**RESPONSE TO SUBMISSIONS REPORT  
SHOALHAVEN HOSPITAL REDEVELOPMENT  
SSD DA 35999468**

**PART A – MAIN REPORT**

### **SSD DA 35999468 SHOALHAVEN HOSPITAL REDEVELOPMENT SHOALHAVEN STREET, NOWRA**

SHOALHAVEN ST DROP-OFF OPTIONS

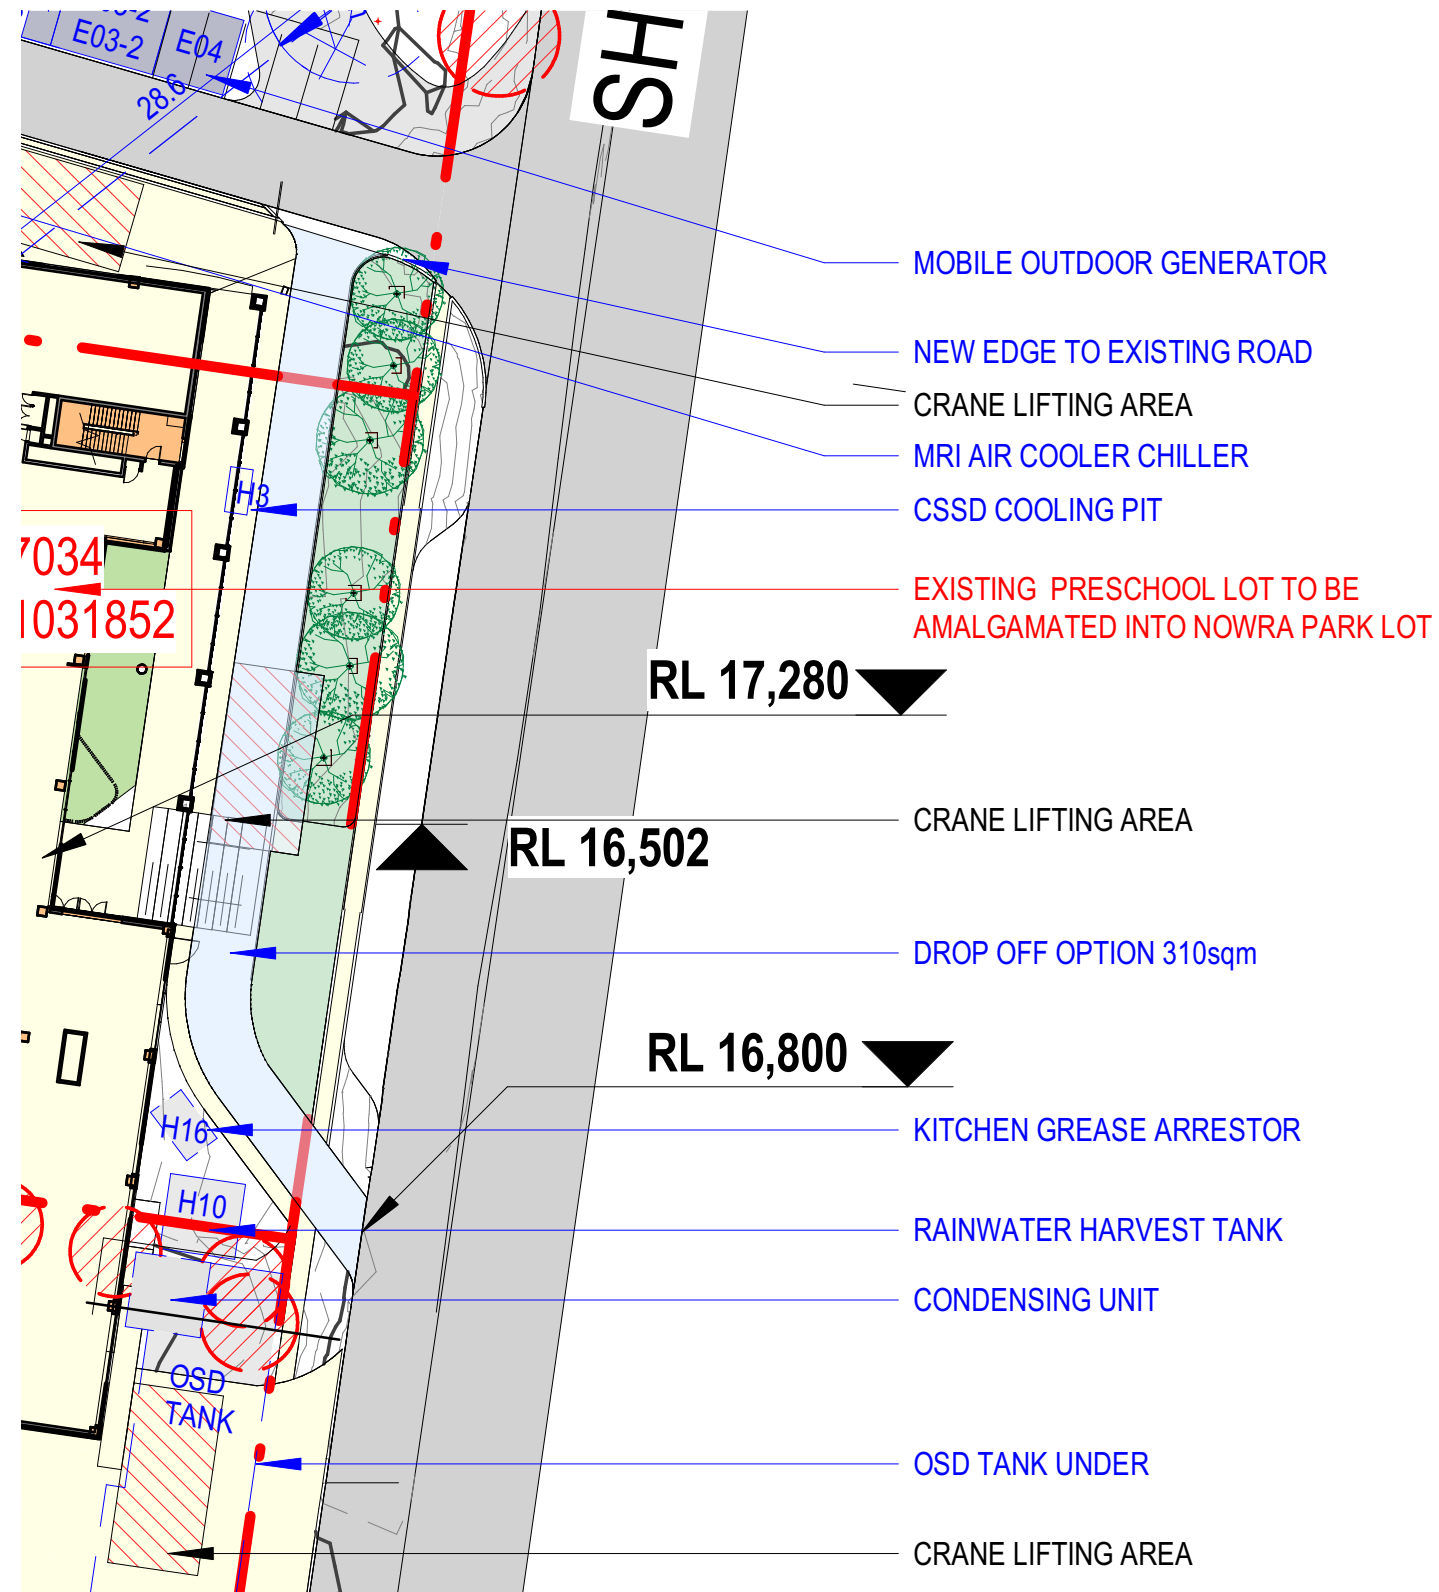
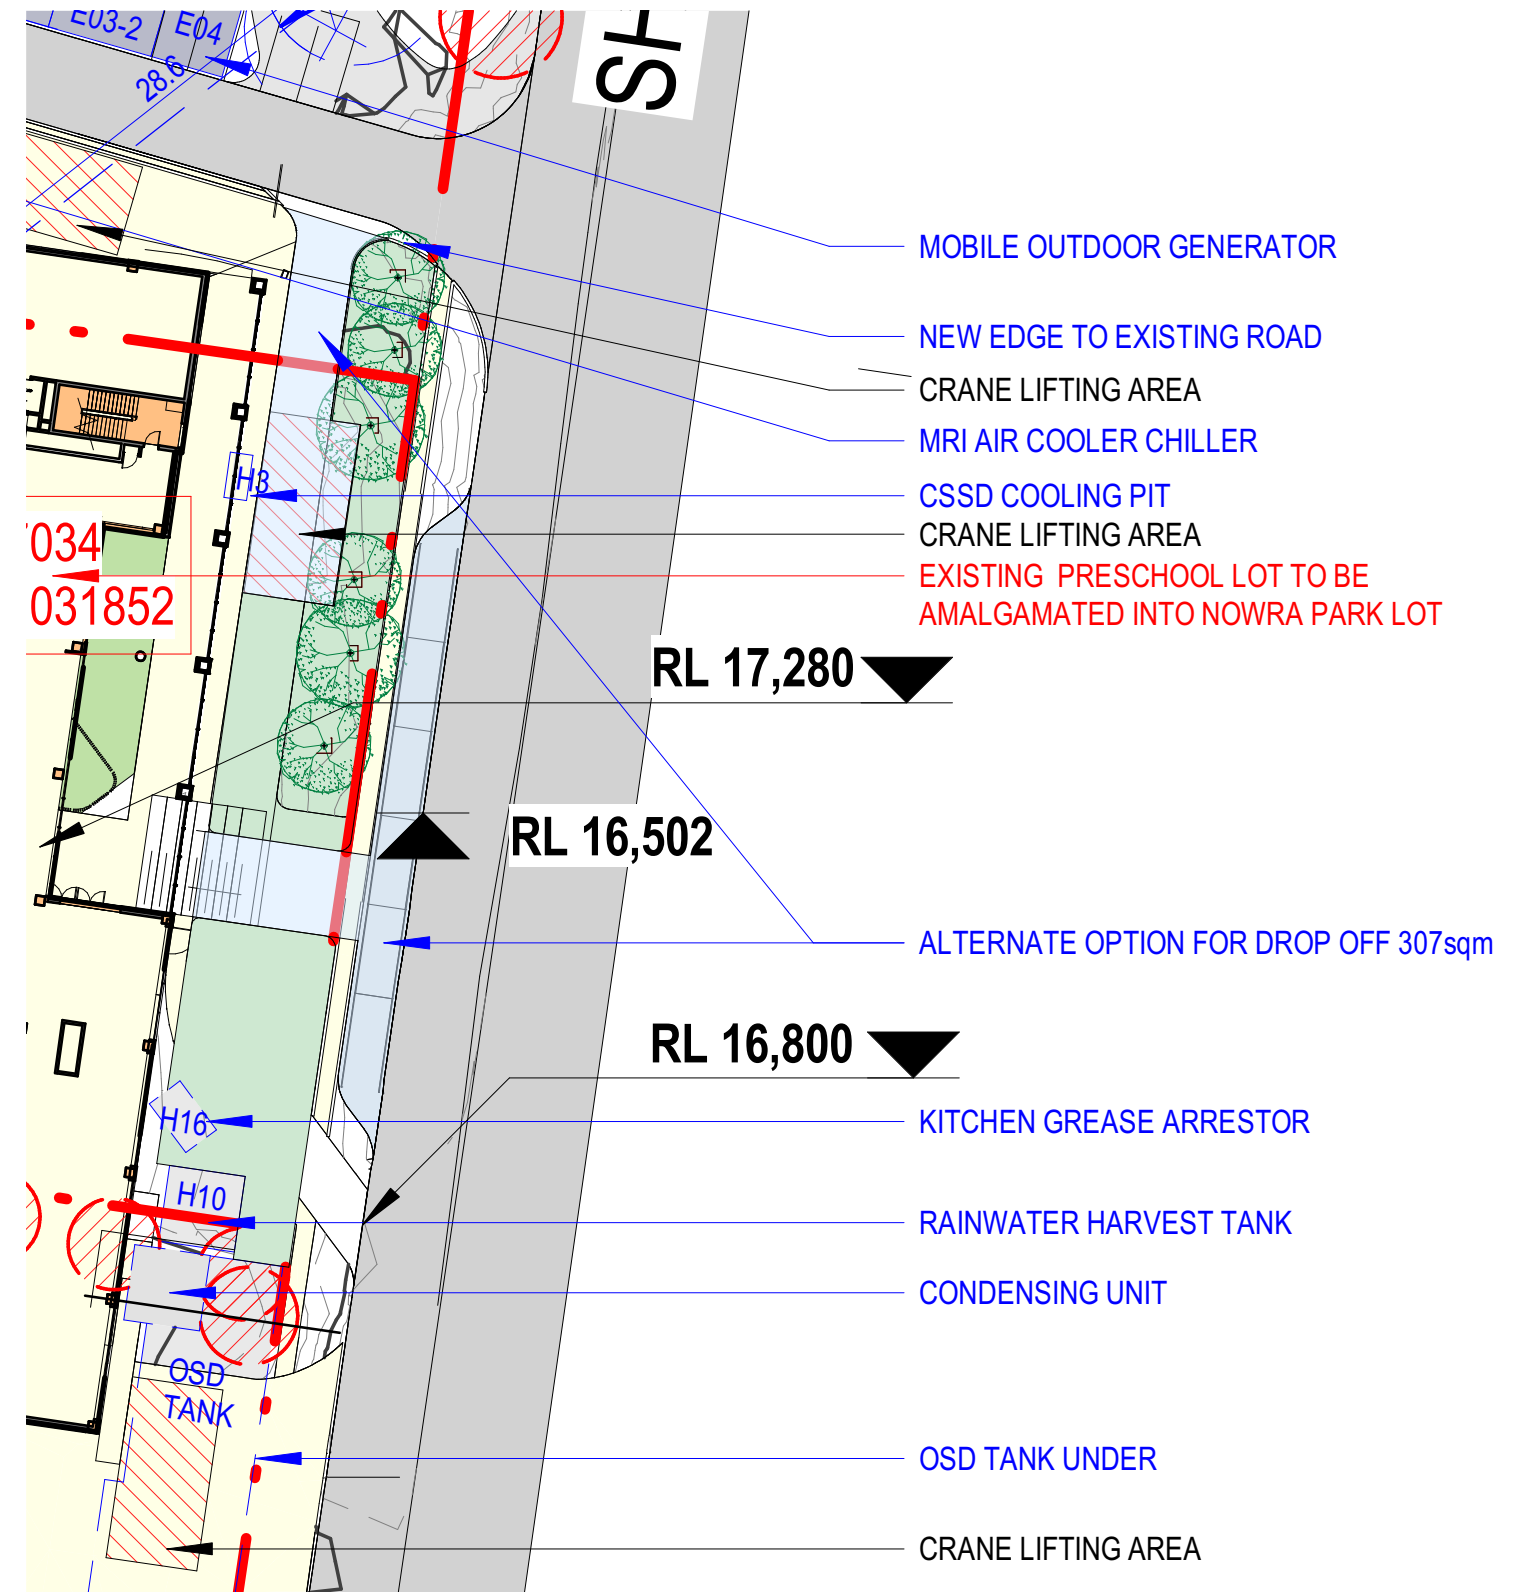
<b>State Design Review Panel (SDRP)</b>	
<p>Page 39 of the Architectural Design Report states that, in response to design issues raised by the SDRP, alternative options for the Shoalhaven Street drop-off are being explored to maximise landscaping to the streetscape.</p> <p>Provide details of the options explored in this respect.</p>	<p>Conrad Gargett has reviewed this comment and advised as follows, and as attached as part of <b>Appendix C</b>.</p> <p>The alternate option that was explored in response to the SDRP comments is shown in the document titled 'Shoalhaven St Drop-off Options' at <b>Appendix C</b>.</p> <p>The minimal increase in landscaped area did not justify the loss of amenity in the drop off area.</p> <p>A road is still required to access the mortuary garage. Hardstand is required for a crane lifting area for plant equipment replacement.</p> <p>Public amenity is compromised with the drop off being further from the entry and closer to road traffic. Undercover access from the drop off would result in an awning structure close to the site boundary.</p> <p>The SDRP was comfortable with the way the drop off design was developed in the following meeting and agreed it was the preferred solution.</p>

Figure 5.1: Proposed Bicycle Storage and End-of-Trip Facilities
Source: Conrad Gargett (BLB-DD-DR-AR-22101, 16/06/22, Rev 7)

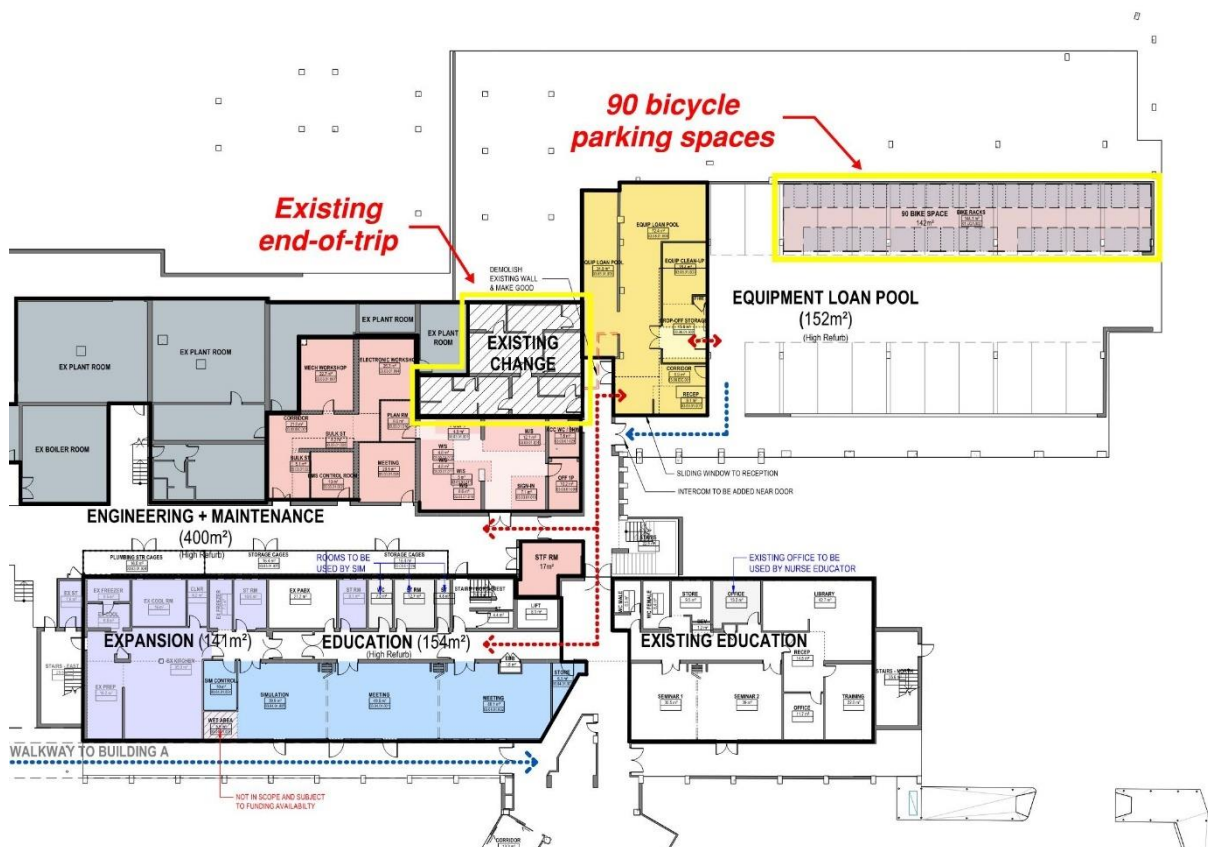
f) <b>Bicycle Parking and End of Trip (EoT):</b> TfNSW notes that there will be 90 bike storage spaces on site, however, it is unclear where these facilities are located within the existing hospital precinct, how many showers and lockers are proposed and where any facilities for members of the public (i.e. secure bike parking) will be provided. A good supply of quality EoT and bicycle parking is considered necessary to further encourage walking and cycling mode shares for both staff and visitors.	
In addition to the above, TfNSW recommends that this bicycle parking and any EoT facilities should be monitored over time to ensure sufficient supply and to encourage active transport both to/from the site for employees, students, patients, and visitors. The bicycle parking should be located at the site at convenient locations, and be safe, secured, and under cover. Some further guidance on bicycle parking and EoT facilities can be found in the <a href="#">cycleway design toolkit</a> .
